# DRB CASE ACTION LOG (PREL & FINAL)

DRB Application No.: 06DRB-01568 (P&F)  
Project Name: SUNDT'S INDUSTRIAL CENTER  
Agent: Southwest Surveying Ltd.

**DRB CASE NO/PROJECT NO: 1005233**

Sidewalk Deferral

**PLAT OF
TRACTS A & B, BLOCK 5
SUNDT'S INDUSTRIAL CENTER
WITHIN PROJECTED SECTIONS 33 & 34, T. 11 N., R. 3 E., N.M.P.M.
ELENA GALLEGOS GRANT
CITY OF ALBUQUERQUE
BERNALILLO COUNTY, NEW MEXICO
JUNE 2006
SHEET 2 OF 2**

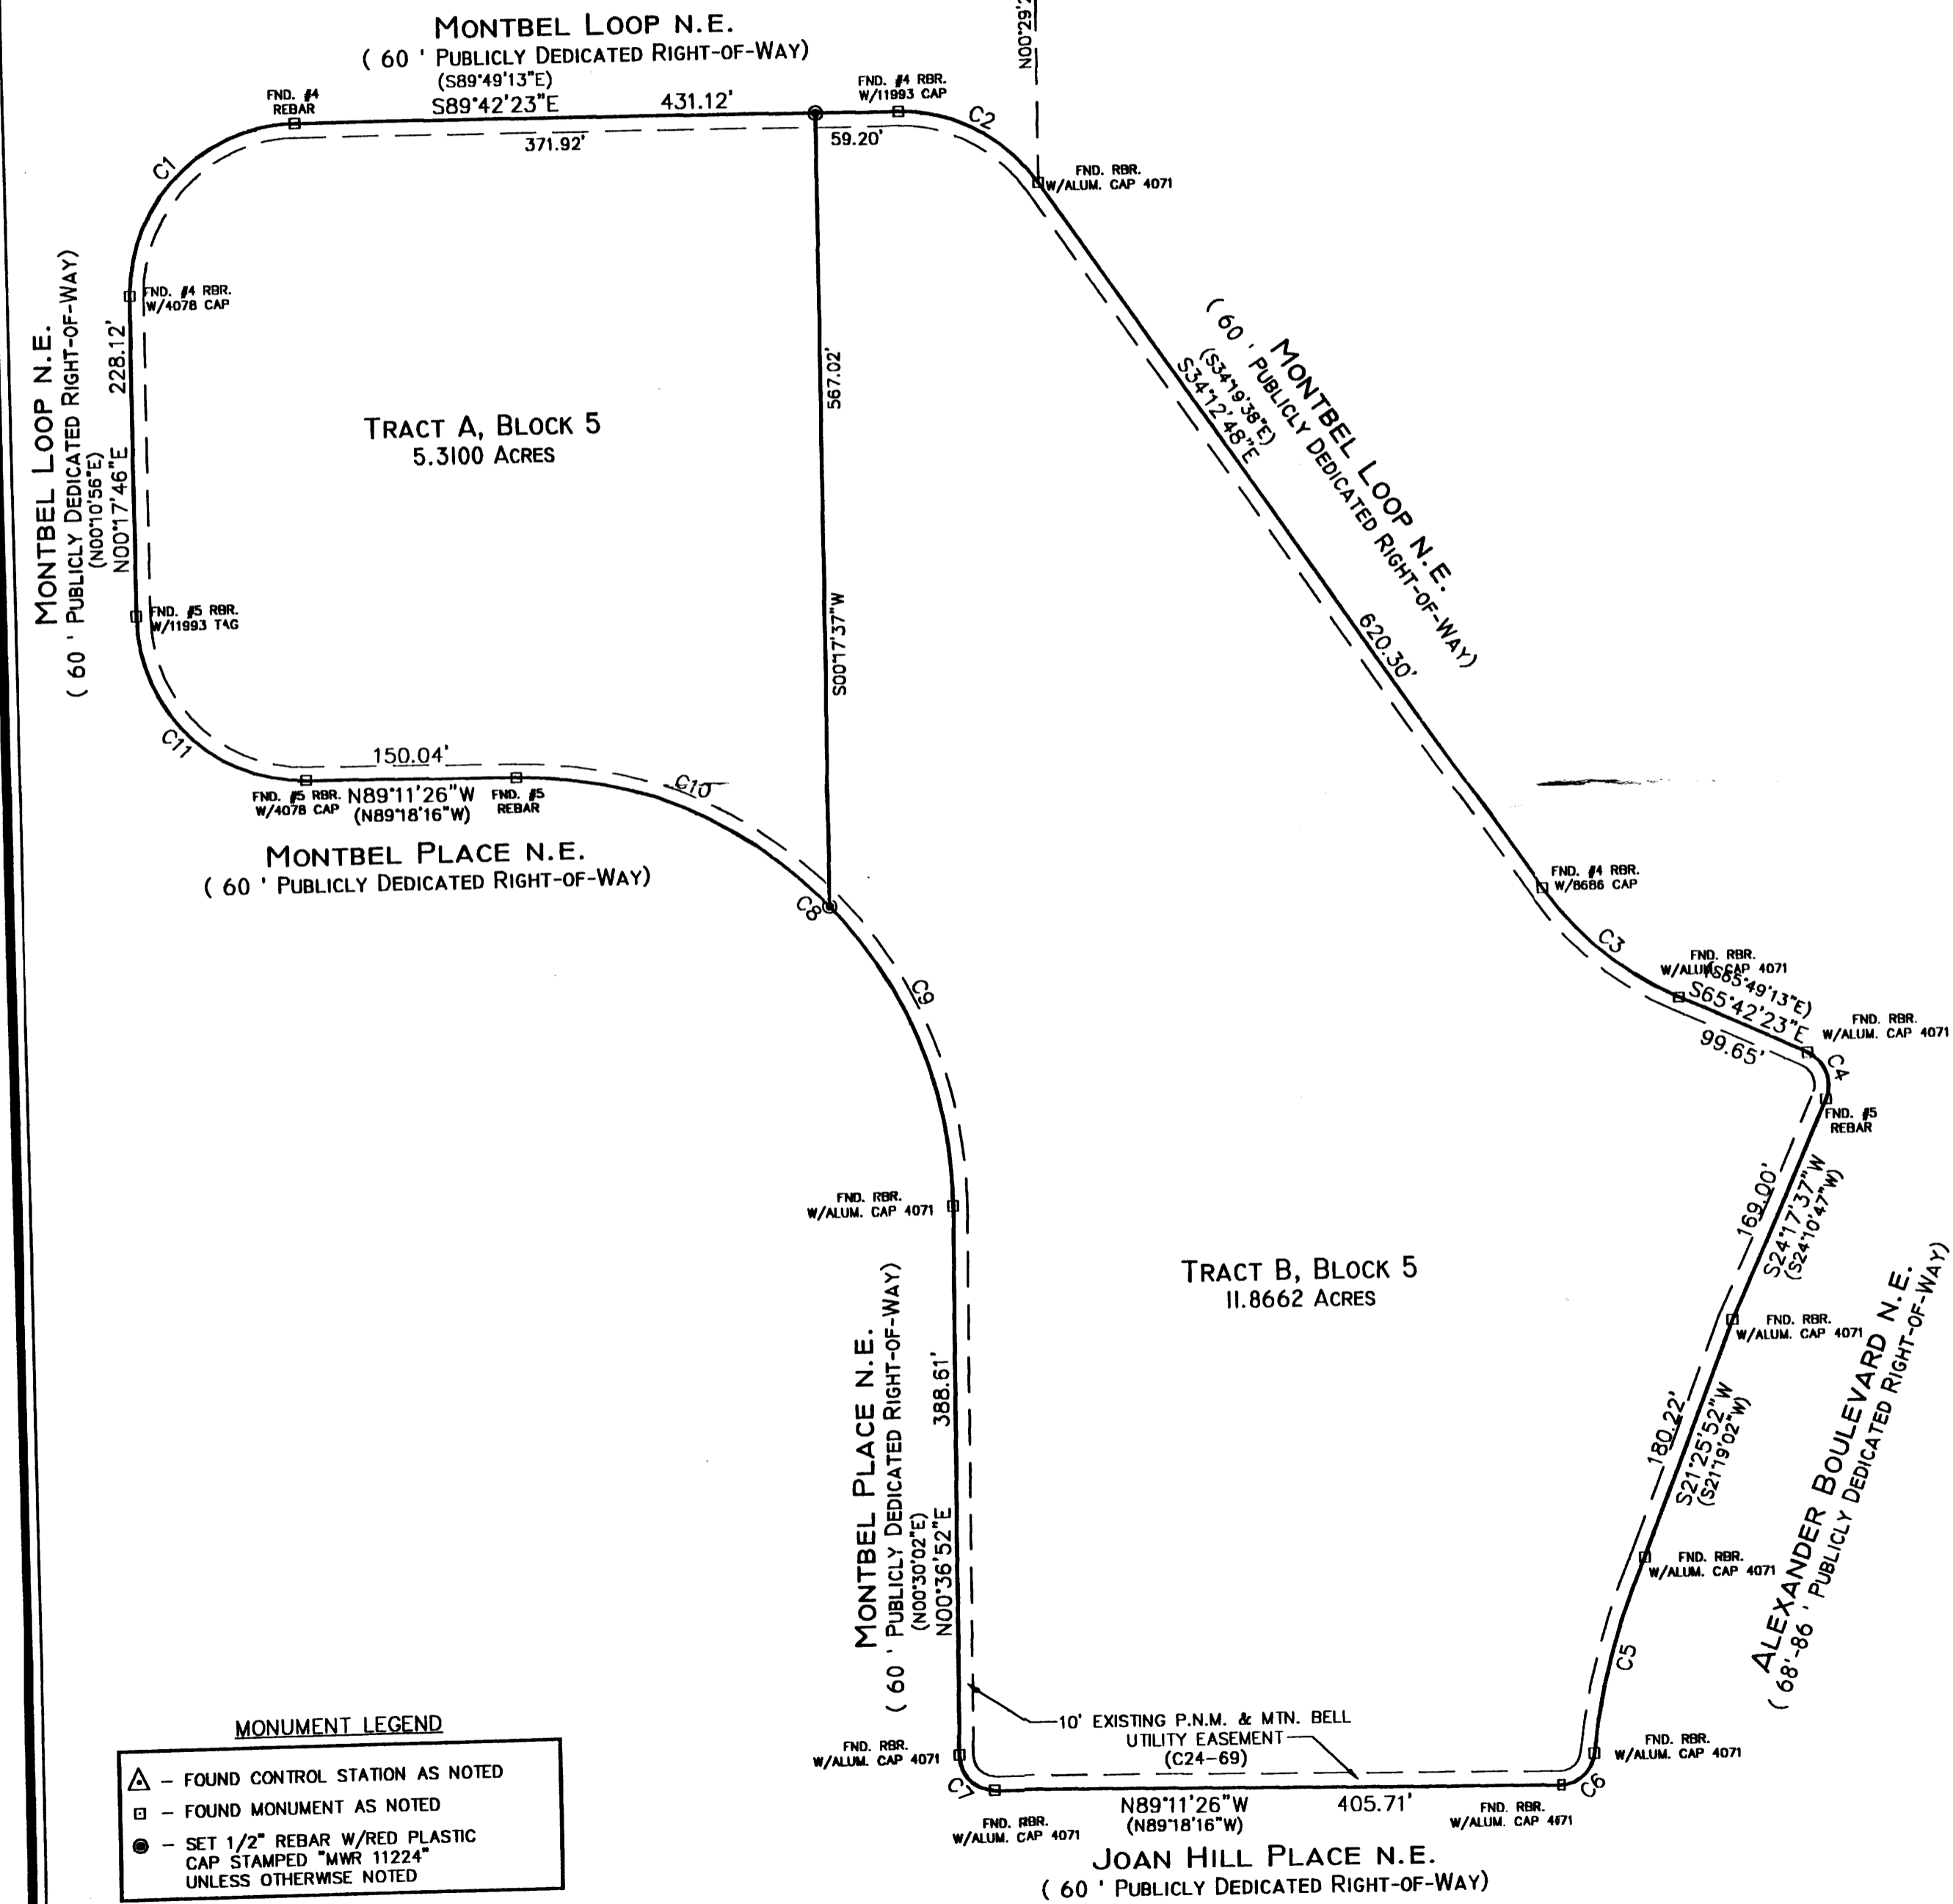
TRANSPORTATION: ARE THE SIDEWALKS IN PLACE?

CITY ENGINEER / AMAFCA: Cross lot drainage easement  
private facilities maintenance covenant. *(Signature)*

A cross lot drainage easement is required.  
Need a private facilities maintenance covenant.
